Application for Removal or Variation of a Condition following Grant of Planning Permission or Listed Building Consent

Number	<input type="text" value="40"/>
Suffix	<input type="text"/>
Property Name	<input type="text"/>
Address Line 1	<input type="text" value="Northumberland Place"/>
Address Line 2	<input type="text"/>
Address Line 3	<input type="text" value="City Of Westminster"/>
Town/city	<input type="text" value="London"/>
Postcode	<input type="text" value="W2 5AS"/>

Excavation of a basement extension below the front garden, lowering of the existing lower ground floor and rear garden level, erection of two-storey glazed infill extension to the rear, reconfiguration of layout for the lower ground to first floor to create a single family dwelling. Landscaping works of rear yard and new stairs to glazed infill extension. Alterations to the front lightwell including relocating the stairs and landscaping the front garden.

19/07849/FULL

Project		40 Northumberland Place, London, W2 5AS		
Title		Proposed Sections AA		
Date	26.11.18	Scale [A3]	1:100	Drawing no.
				379-PL300
Rev.				3

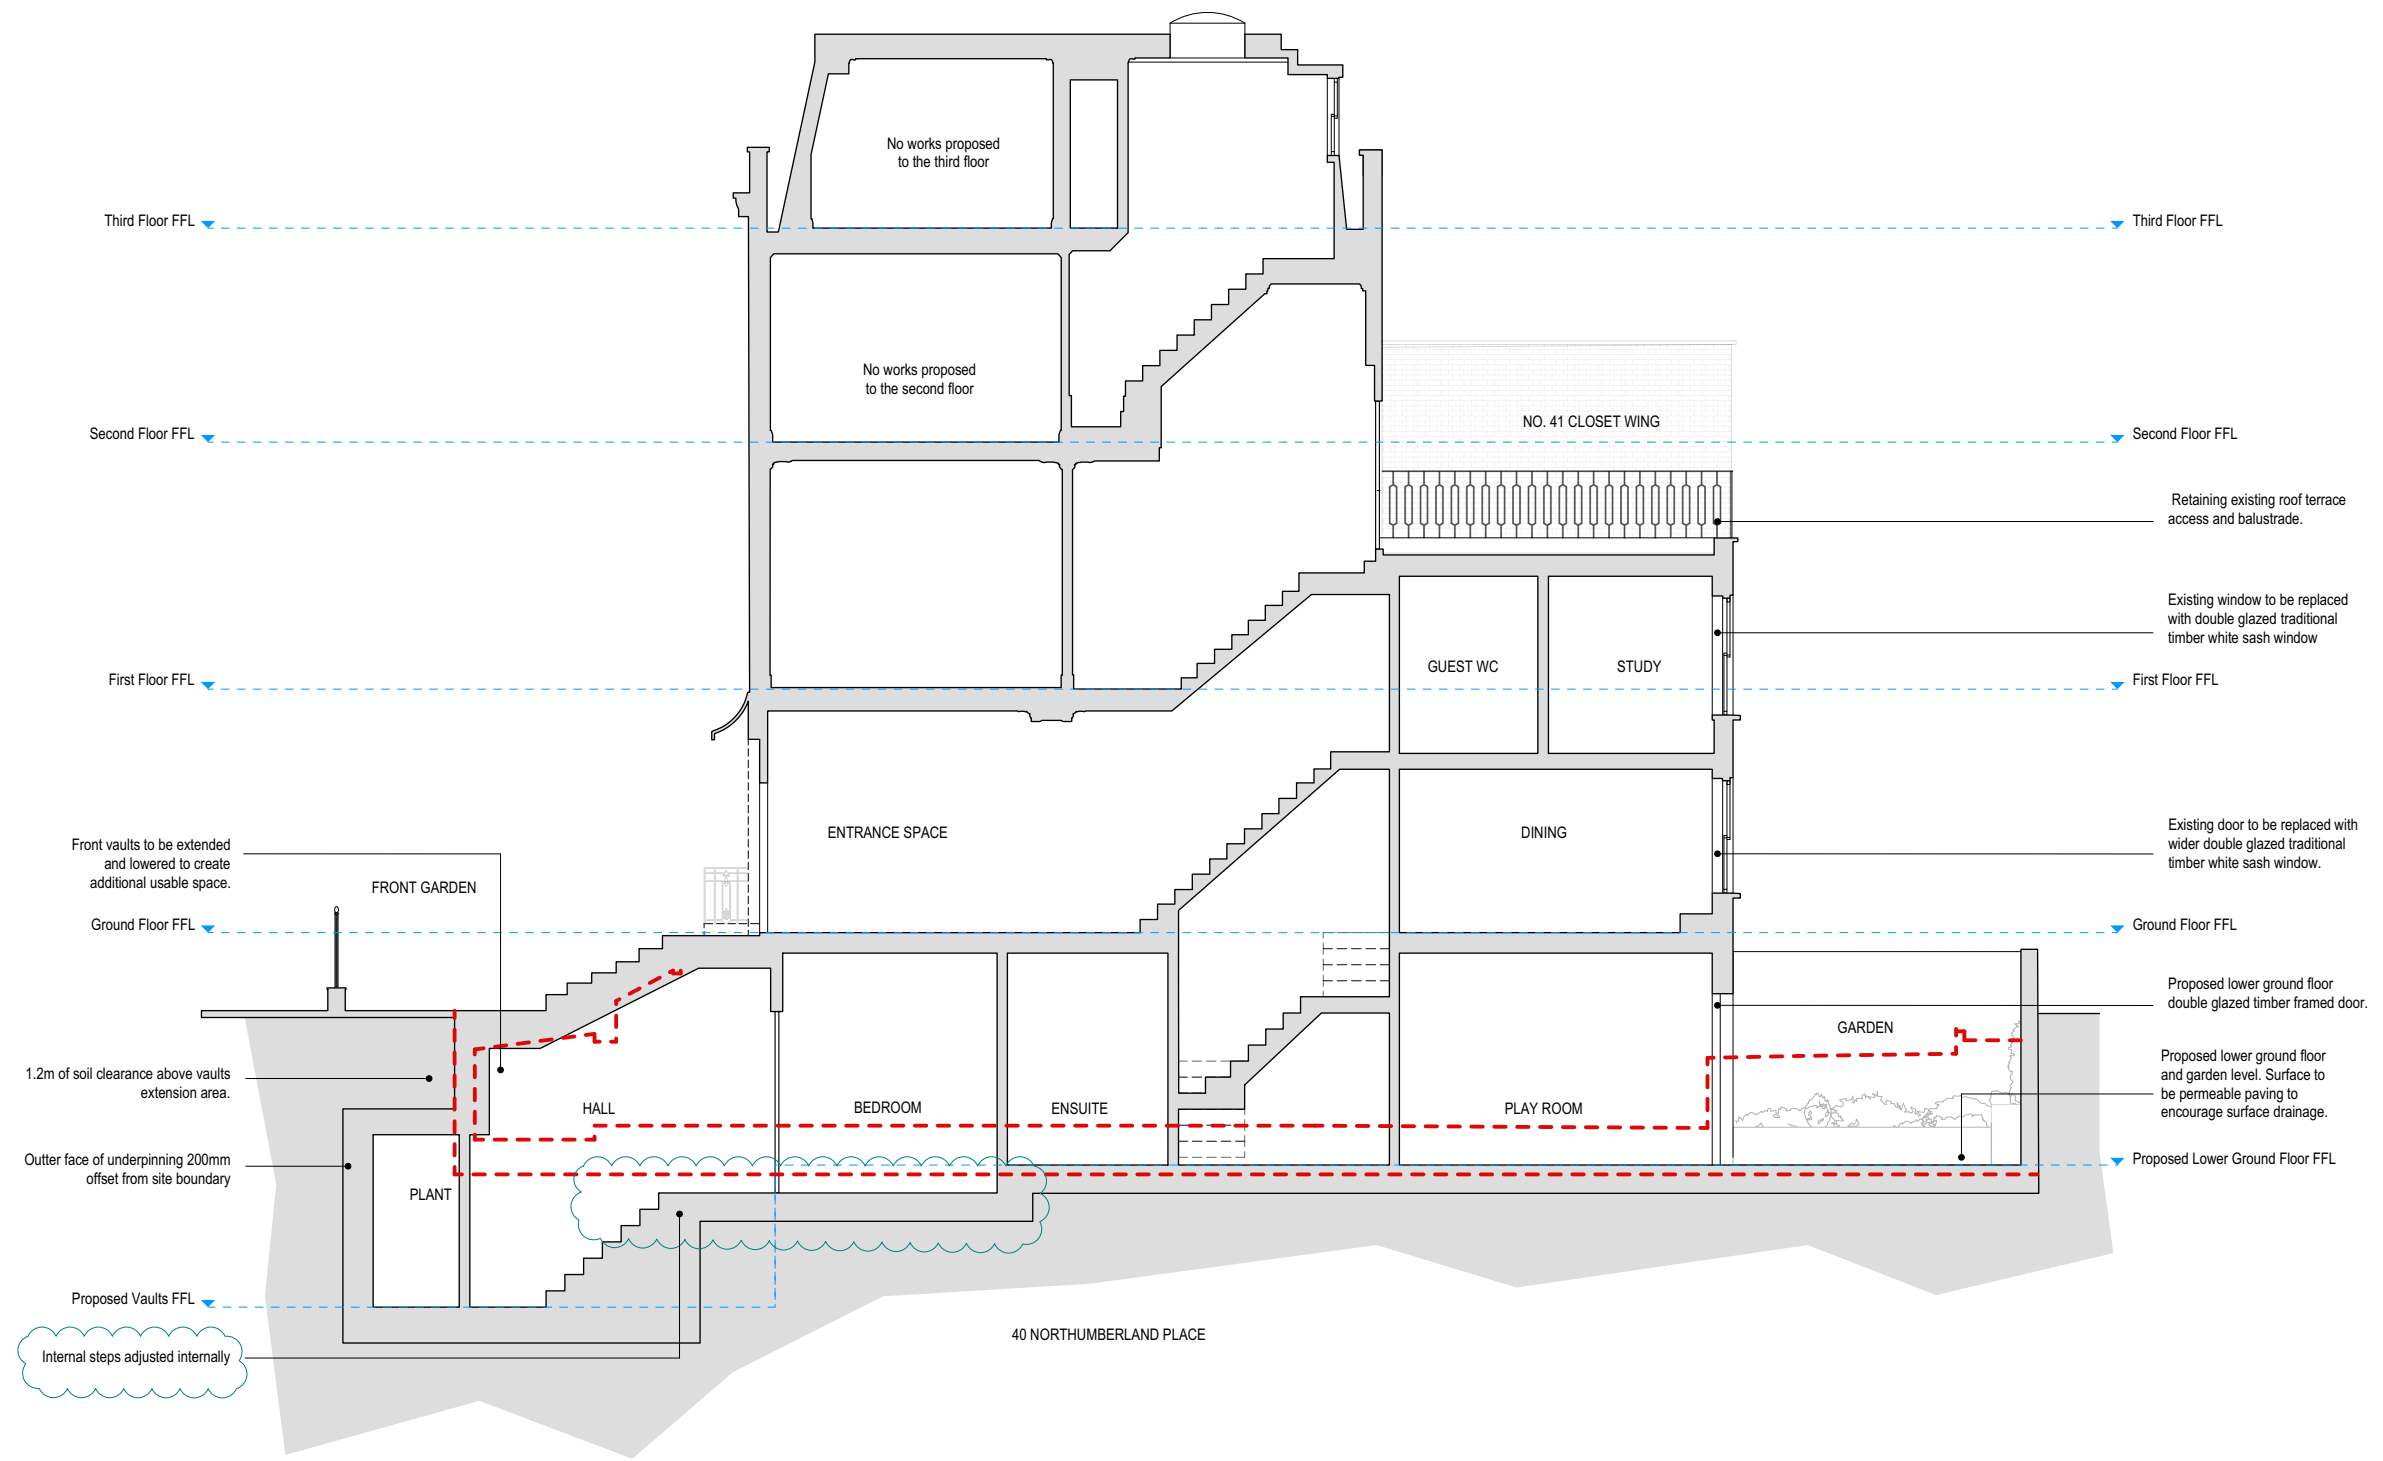
- Alterations to the front garden area including reducing the size of the lightwell, changes to the front entrance steps and repositioning of the bin store and planters;
- Changing the style of lower ground floor (secondary) front entrance door to include a fanlight;
- Rotating the rooflight to the glazed infill extension; and
- Adjusting the internal step arrangement to the lower ground floor and minor internal layout changes.

We would like to substitute the approved drawings (379-PL100 Rev 1; 379-PL200 Rev 1; 379-PL300 Rev 1; and 379-PL301 Rev 1) to proposed drawings which are numbered: 379-PL100 Rev 4; 379-PL200 Rev 3; 379-PL300 Rev 3; and 379-PL301 Rev 3.
